59 Washington Ave - Permit #2016-02490

Ann Machado <amachado@portlandmaine.gov>
To: jedtharris@gmail.com

Tue, Oct 4, 2016 at 1:57 PM

59 Washington Ave
Unit 1-EA key plan

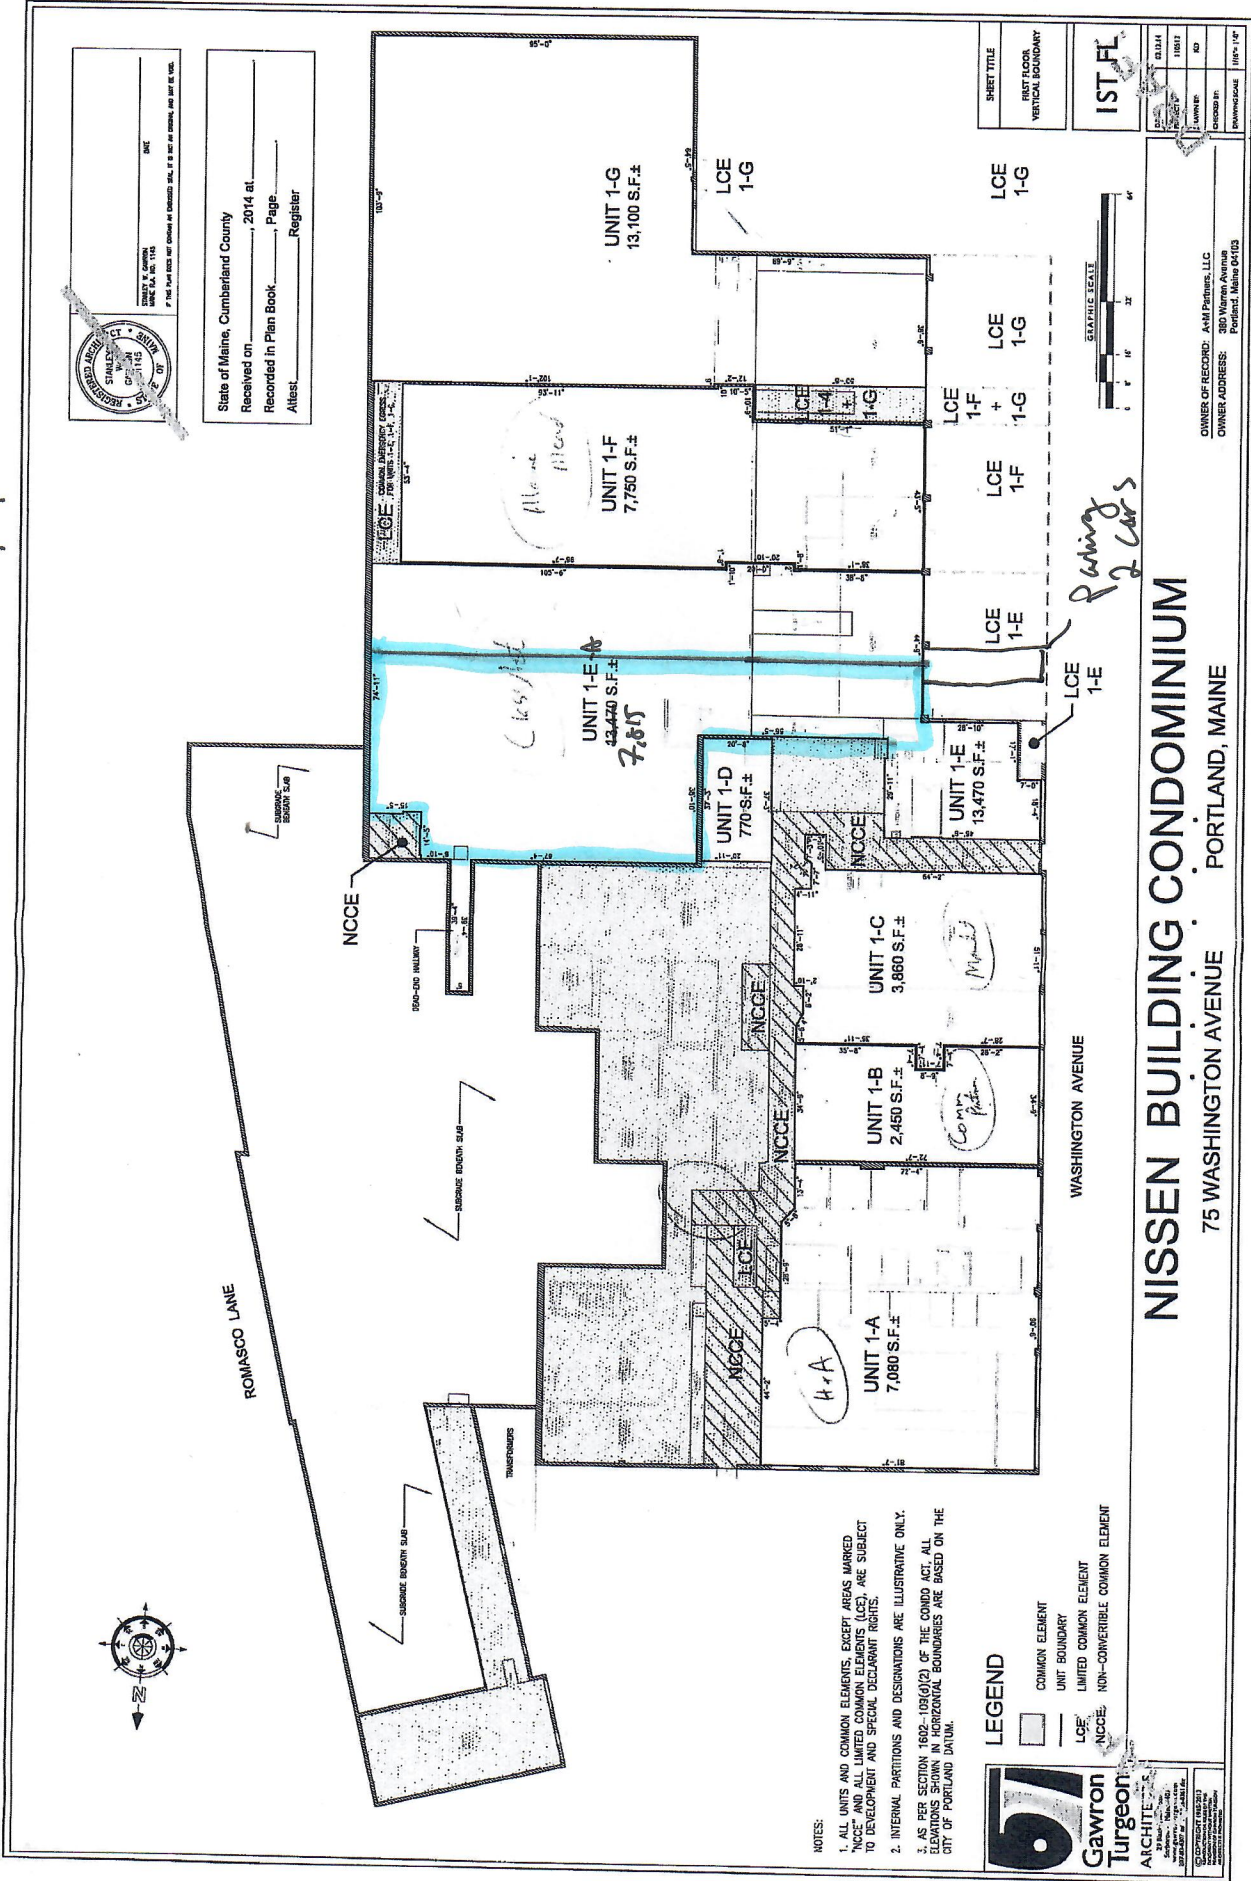
1. The square footage provided for space on the application is 7815 sf. Required parking is one space for each 400 sf; $7815/400 = 19.53 = 20$ spaces. Need to show where these 20 spaces are being provided on the site (No site plan provided).
2. Need a key plan to show where this space is in the building.

Attached is the key plan for the space, apologies for not including in the original submission. It's in the warehouse next to the distillery.
